PEDESTRIAN WIND ENVIRONMENT STATEMENT
HURLSTONE AGRICULTURAL HIGH SCHOOL
(HAWKESBURY)

WD849-01F02(REV0)- WS REPORT

12 SEPTEMBER 2017

DRAWING
Level 2 FFE - Overall

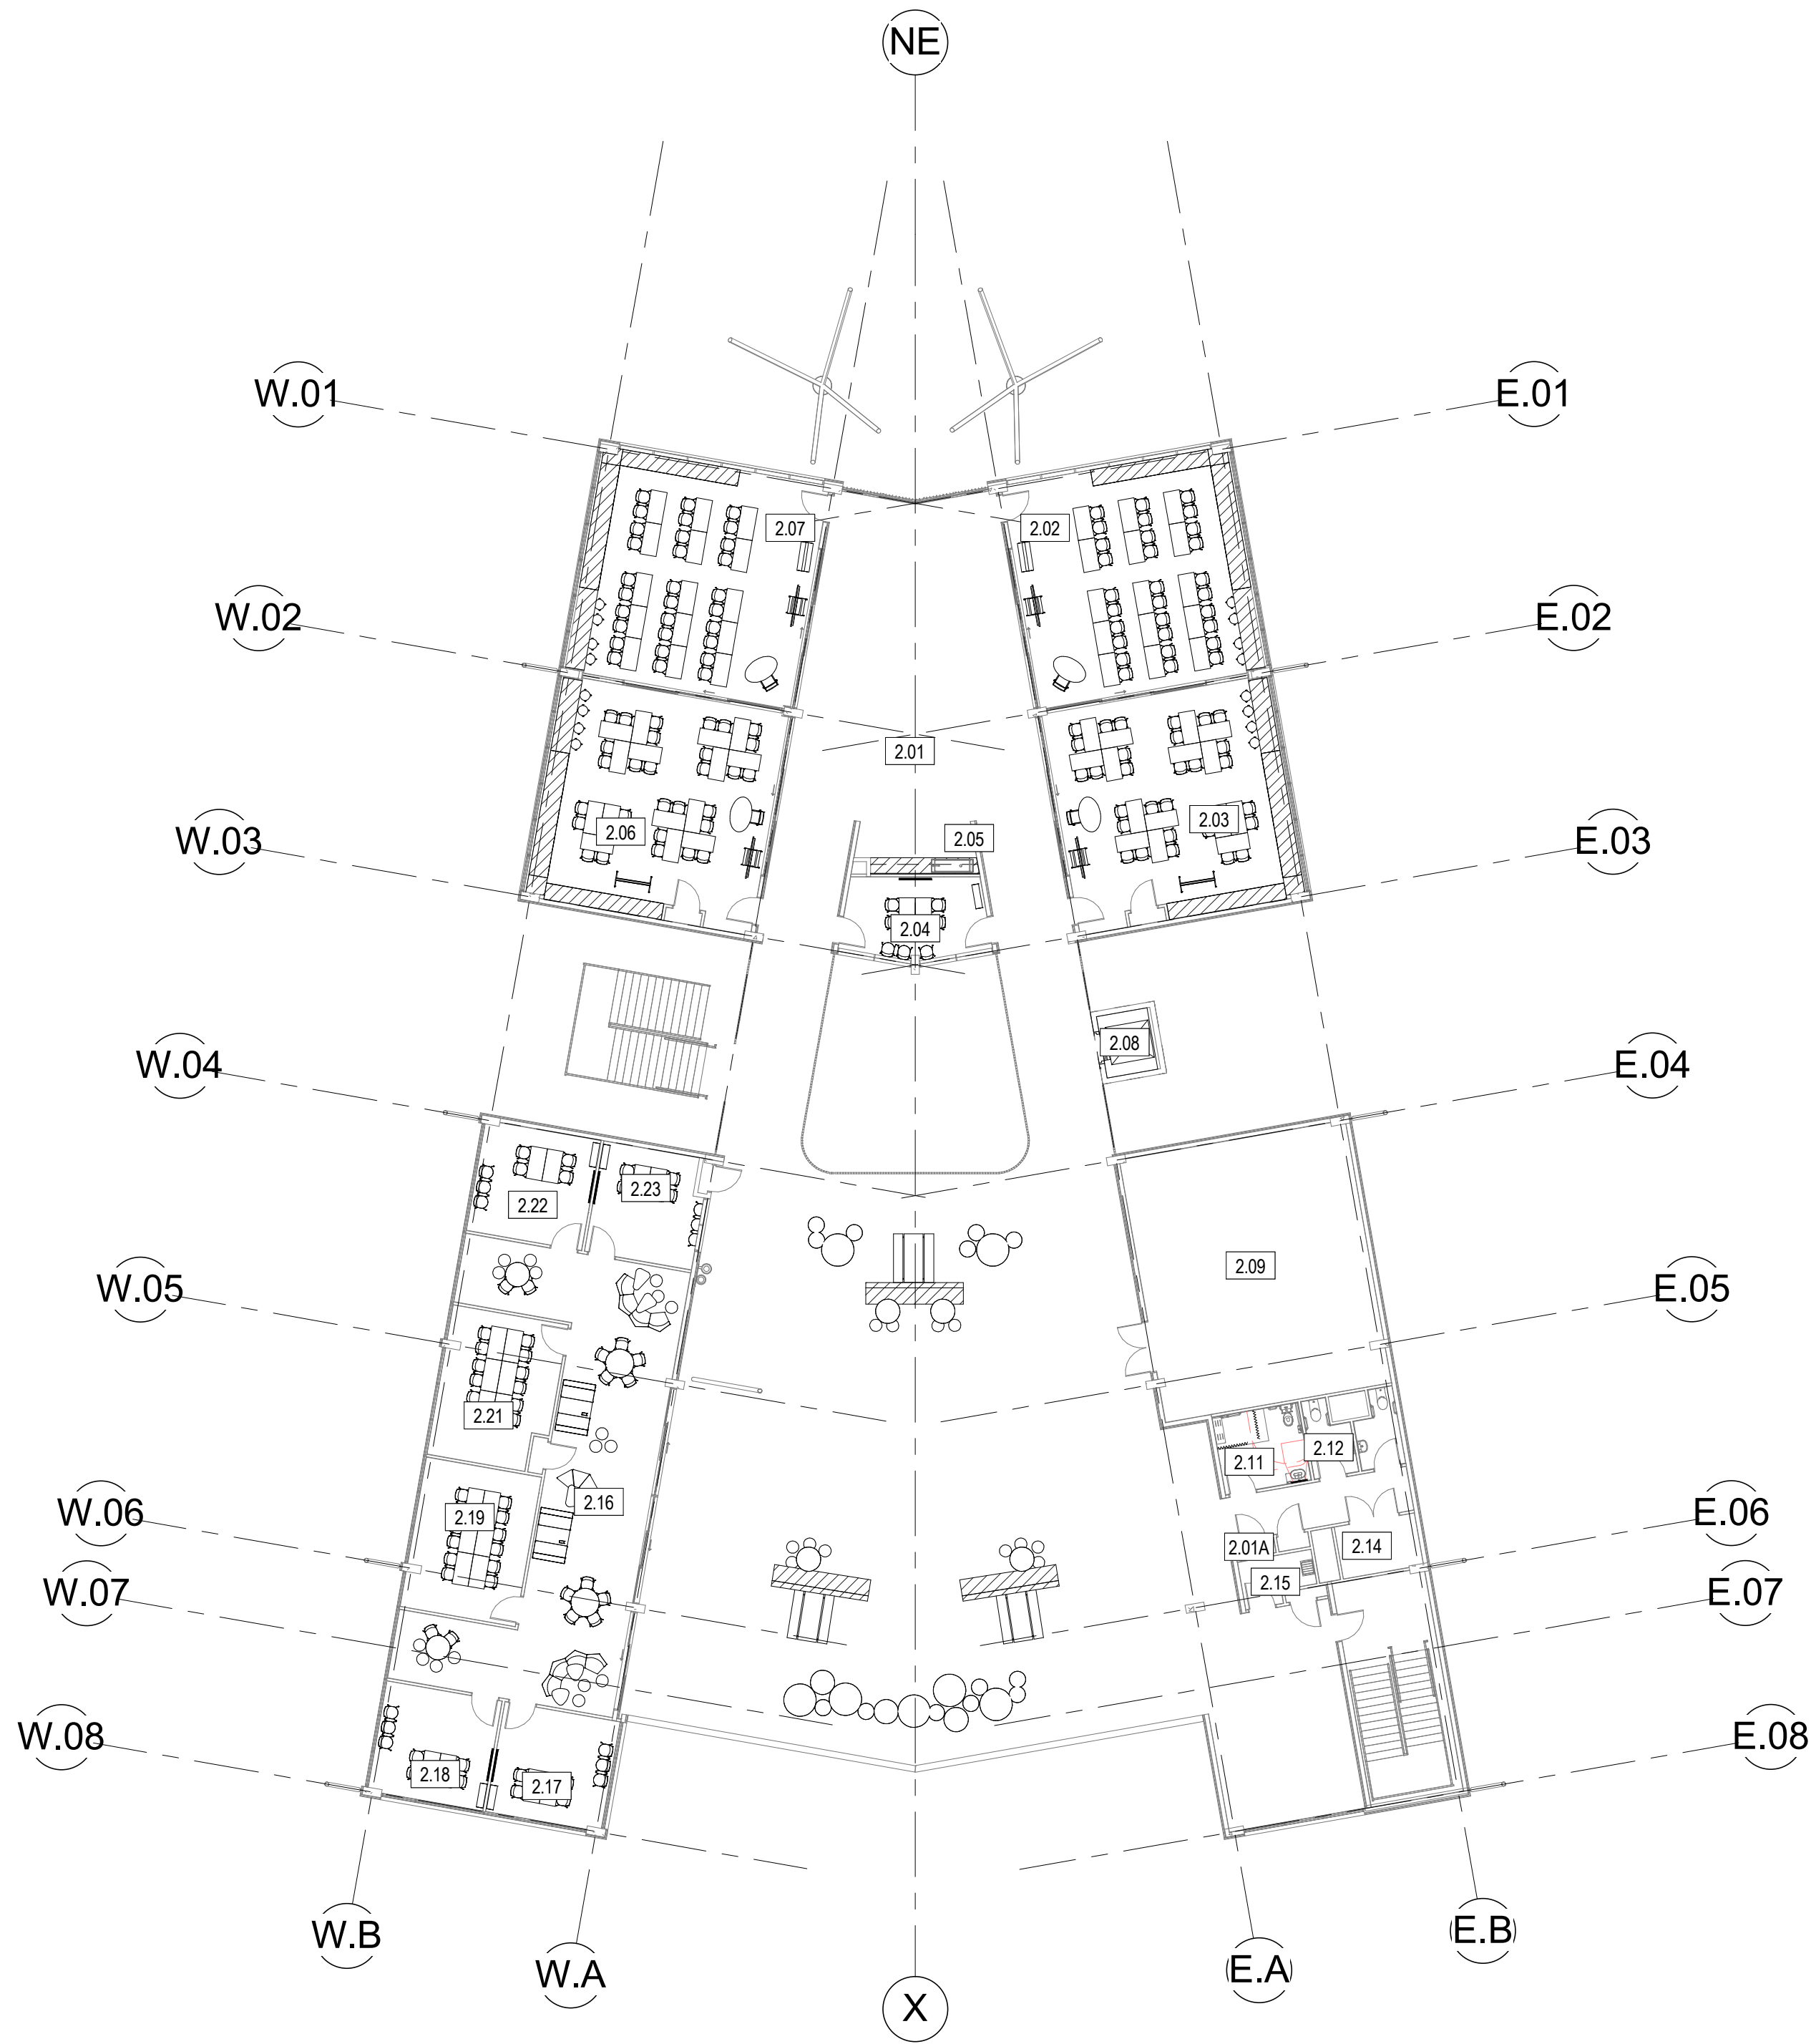
The circulation areas on Levels 01 and 02 of Building 03 are prone to adverse wind conditions as a result of the direct impact of the westerly winds. Similarly the circulation areas on Level 02 of Building 02 are prone to adverse wind conditions due to the direct impact of the southerly winds. To mitigate these adverse wind conditions, it is recommended that the proposed impermeable screen on the southern aspect of Level 02 of Building 02 be retained in the final design of the development, as indicated in Figure 3e. Furthermore, to mitigate the adverse wind conditions for the circulation areas on Levels 01 and 02 of Building 03, it is recommended that the proposed impermeable balustrades on the north-western and south-western corners of Levels 01 and 02 of Building 03 be retained in the final design of the development, as indicated in Figures 2d and 2e.

- Retain the proposed impermeable balustrades on the south-western and north-western corners of Level 02 of Building 03 in the final design of the development.
- Retain the proposed impermeable screen on the southern aspect of Level 02 of Building 02 in the final design of the development.

DRAWING
Ground Floor Overall GA

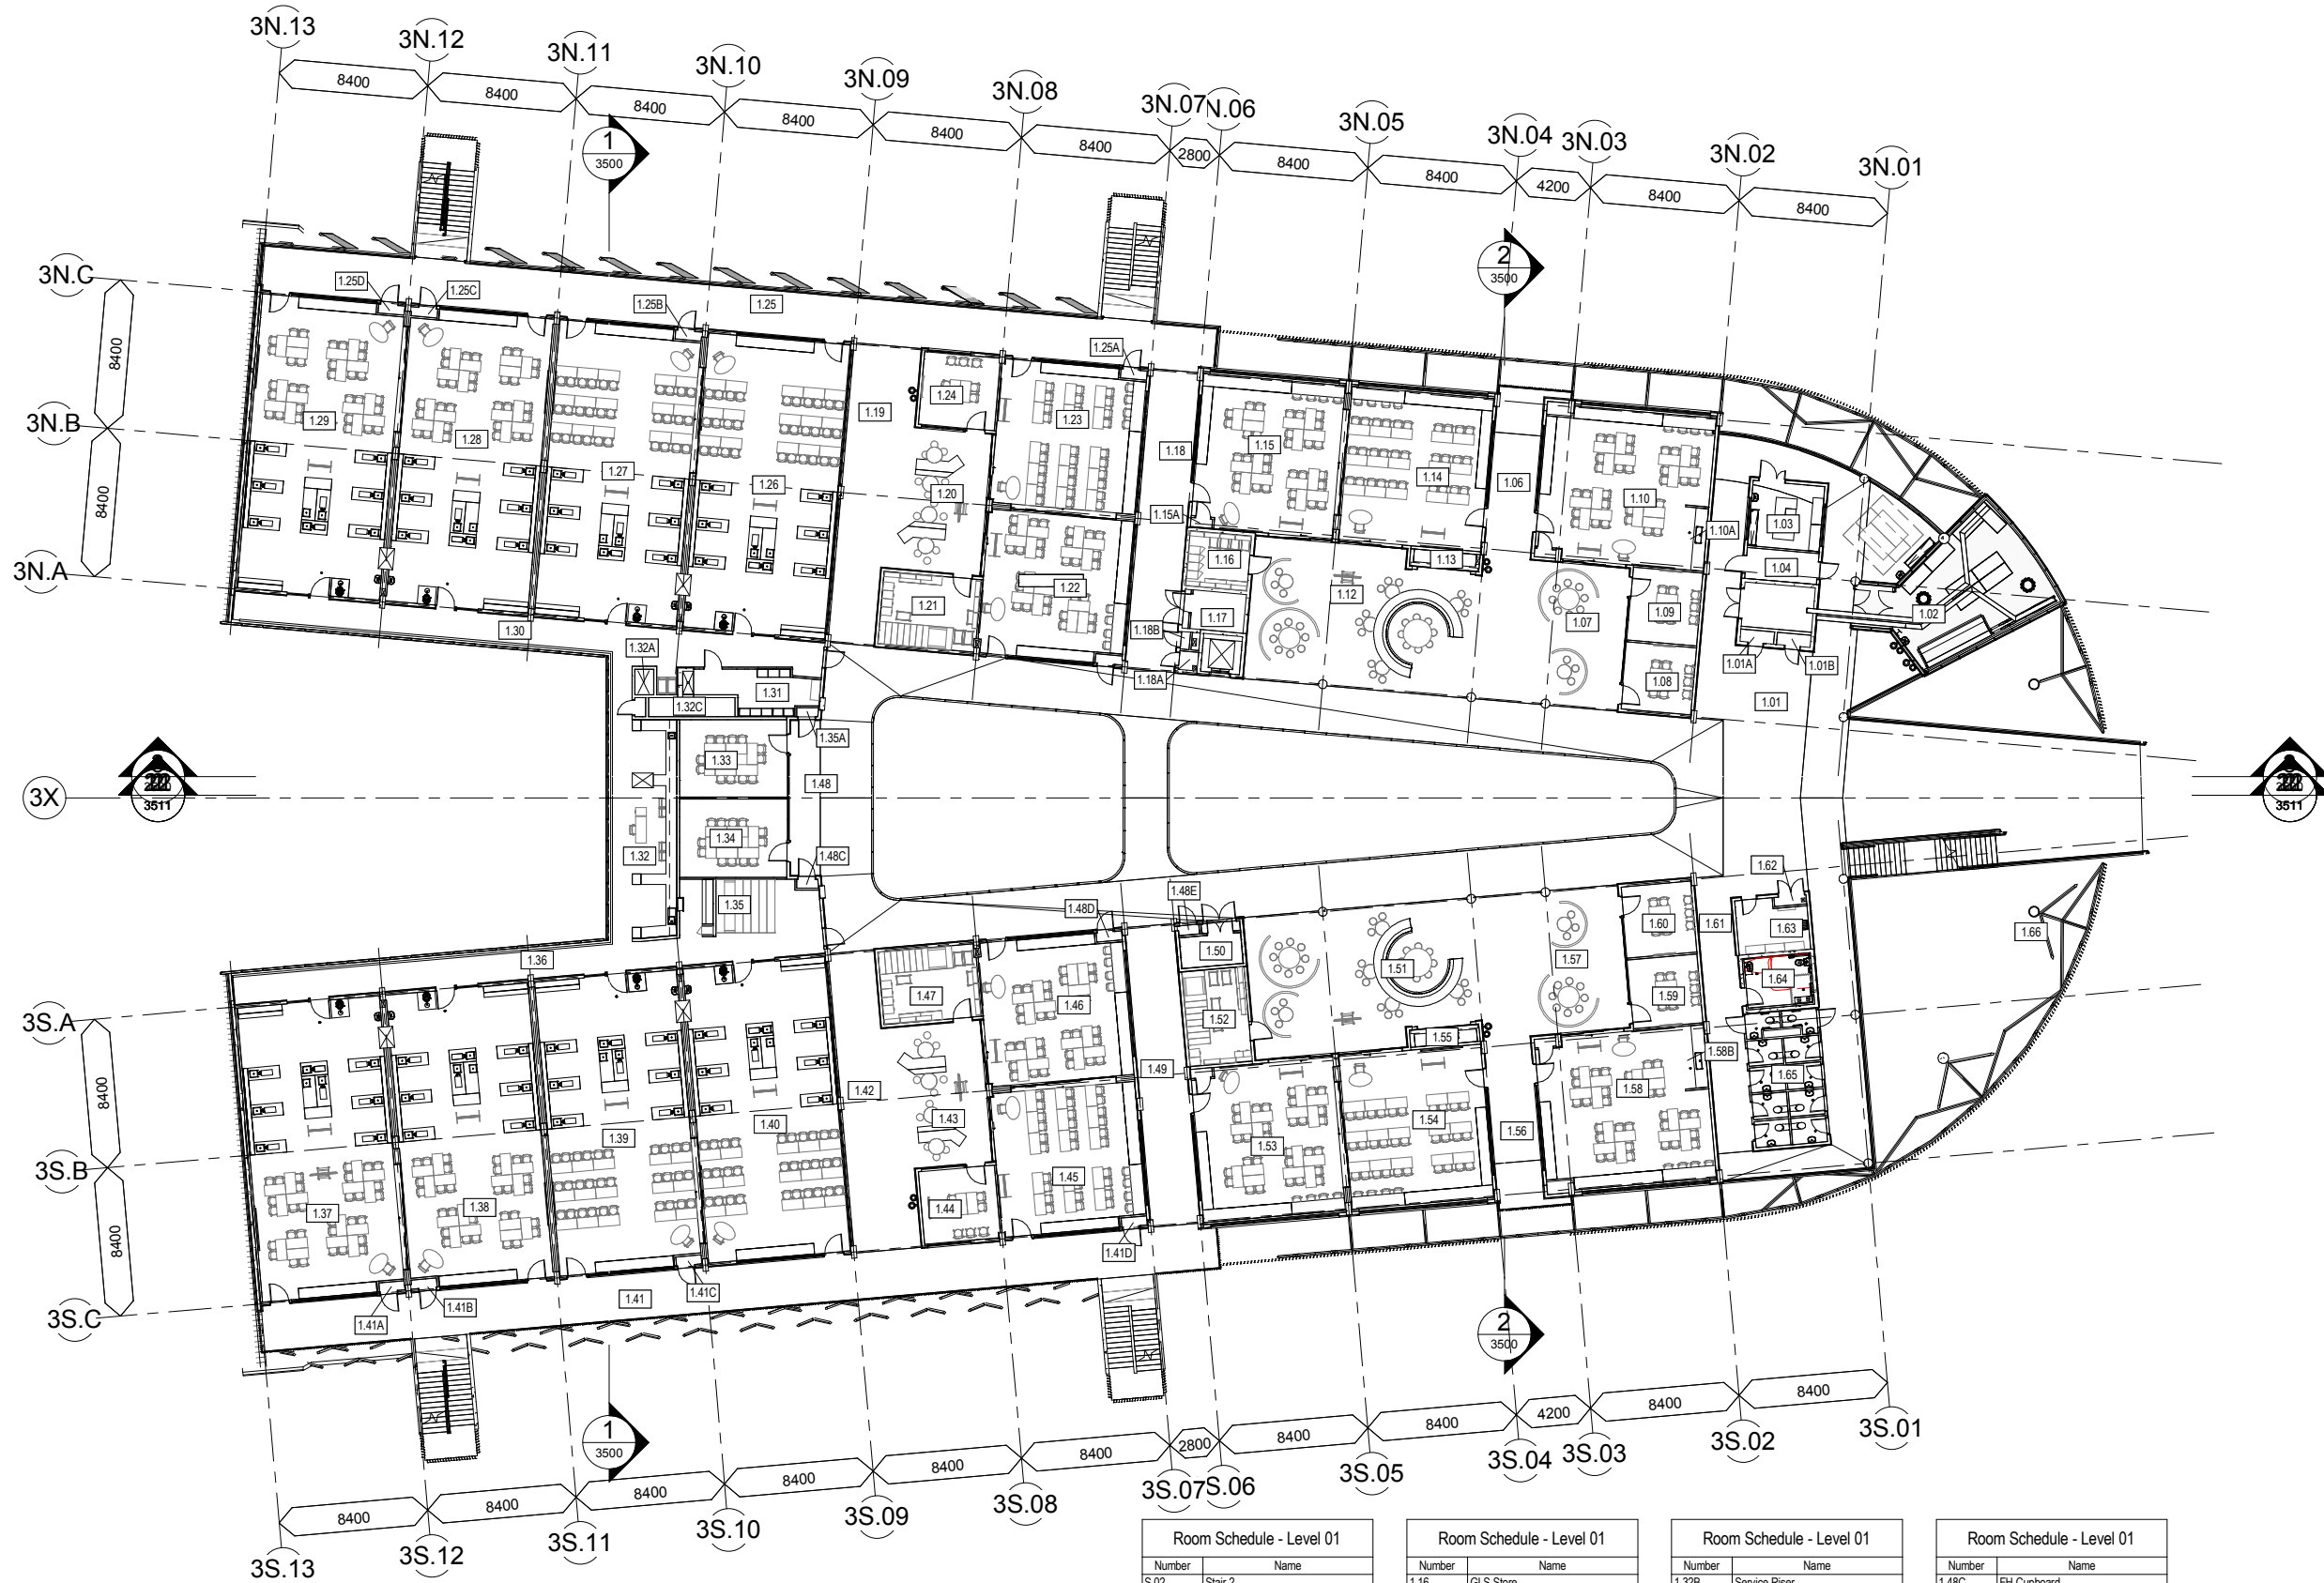
The ground level areas within Building 03 are prone to adverse wind conditions due to the direct impact of the westerly winds. It is expected that the westerly wind will funnel through the ground floor of Building 03 and accelerate through to the area within the circle ring worsening wind conditions. Furthermore, there may potential for pressure driven flow through the opening cavities of Building 03 due to the positively pressured ground floor area and the negatively pressured rooftop cavity. It is expected that this potential pressure differential will cause the westerly wind to accelerate through the circulation areas on Levels 01 and 02. To mitigate these adverse wind conditions, it is recommended that a baffled arrangement of full height impermeable screens be included on the Ground Floor of Building 03, as indicated in Figures 2a, 2b and 2c. It is expected that the impermeable screens will cause the westerly wind to stagnate enhancing the wind conditions throughout the circulation areas on Levels 01 and 02 and the area within the circle ring.

- Retain the proposed door at the end of the walkway of Building 01 in the final design of the development.
- Include a baffled arrangement of full height impermeable screens on the Ground Floor of Building 03.
- Include one of the following options in the area between the accommodation building and Building 02, the area between Buildings 02 and 03 and the area between Buildings 03 and 04:
 - Option 1: Include an arrangement of densely foliating evergreen trees with interlocking canopies.
 - Option 2: Include an arrangement of densely foliating evergreen shrubs. It is recommended that the height of the vegetation and planter box be a height of at least 1.5m in order to be effective in wind mitigation.
 - Option 3: Include a number of full height impermeable screens between each of the buildings mentioned above.
